to:	Lloyd Phillips & Associates Ltd. - <b>Christine McCuaig</b> - <a href="mailto:christine@lloydphillips.com">christine@lloydphillips.com</a>
re:	Geotechnical Design Summary Details <b>Proposed Residential Development</b> <b>2710 Draper Avenue - Ottawa</b>
date:	November 28, 2017
file:	PG1630-MEMO.06
from:	Nicholas Zulinski

Further to your request and authorization, Paterson Group (Paterson) prepared the current memorandum to provide a grading plan review for the proposed commercial buildings at the aforementioned development. The following memorandum should be read in conjunction with Paterson Report PG1630-3 Revision 1 dated November 28, 2017.

- ☐ Grading Plan - Project No. 17-927 - Drawing No. GP-1 - Revision 3 dated November 28, 2017.

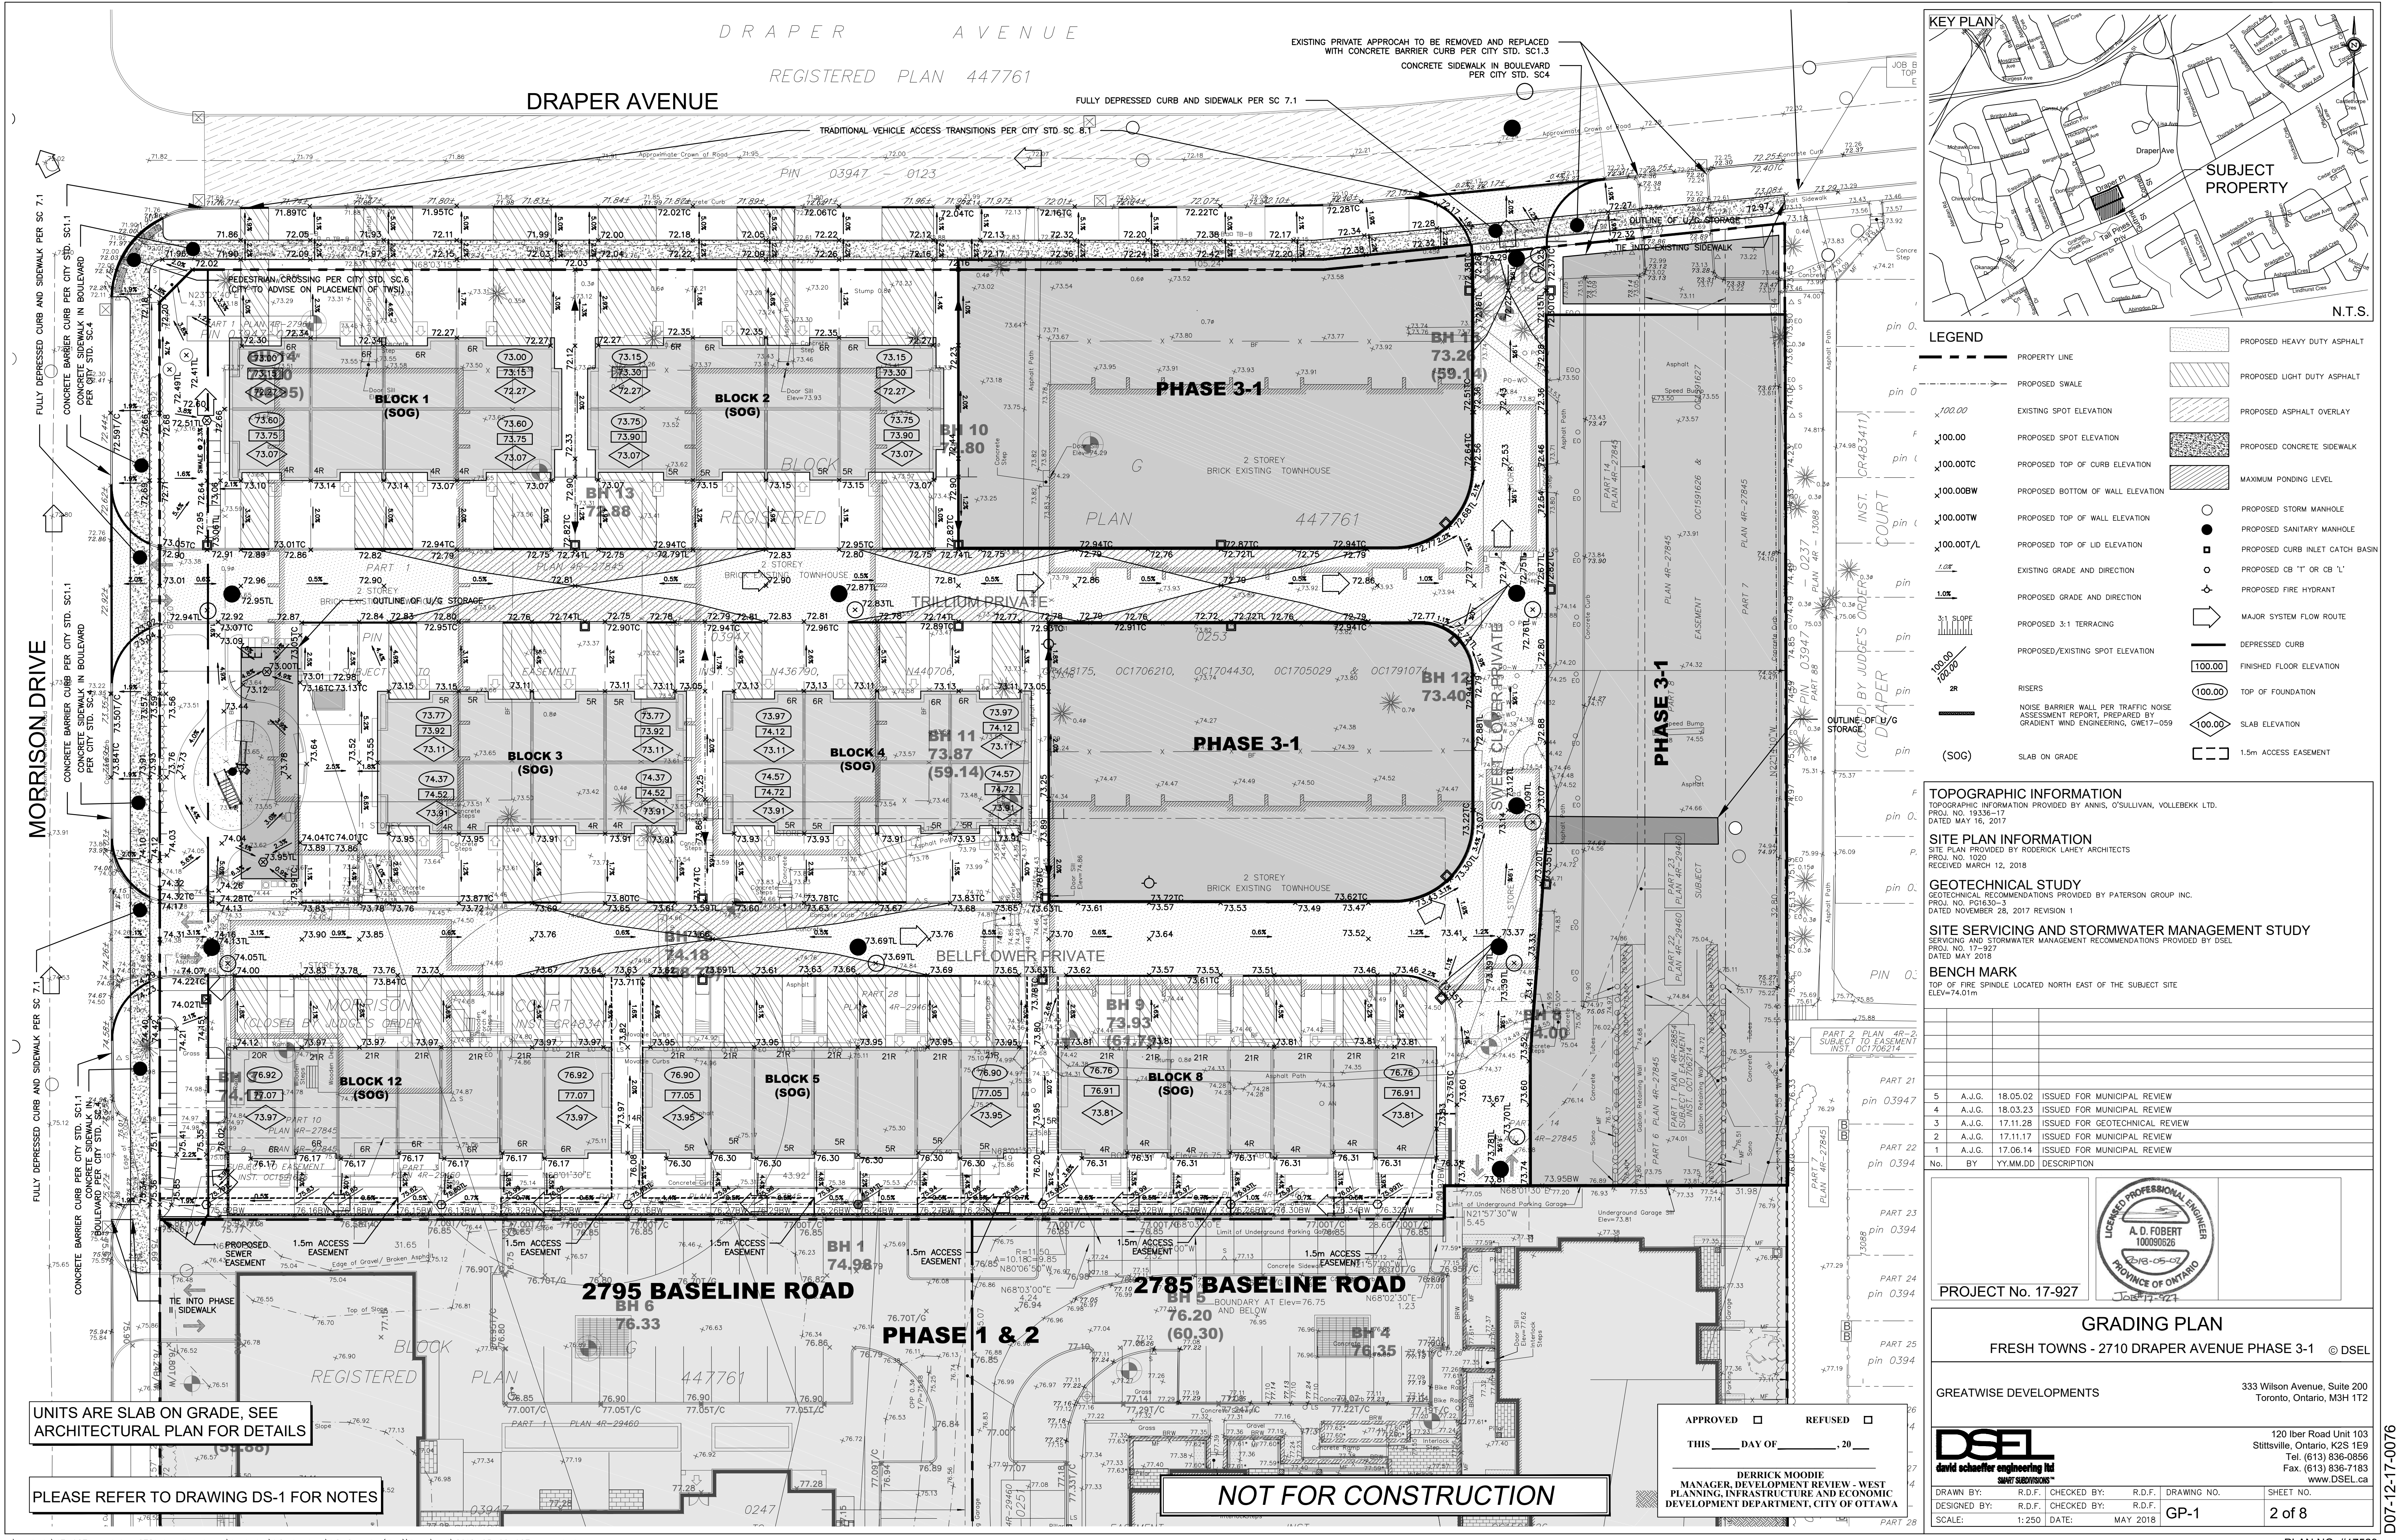
Based on our review of the above noted grading plan, there were some minor instances where the permissible grade raise was exceeded. However, upon further review of both the existing soil profiles and the proposed grading requirements, the proposed grades are considered acceptable from a geotechnical perspective. Therefore, no lightweight fill is required at the subject site.

Table 1 attached provides a grading summary and lightweight fill (LWF) requirements for the subject blocks based on our grading plan review.
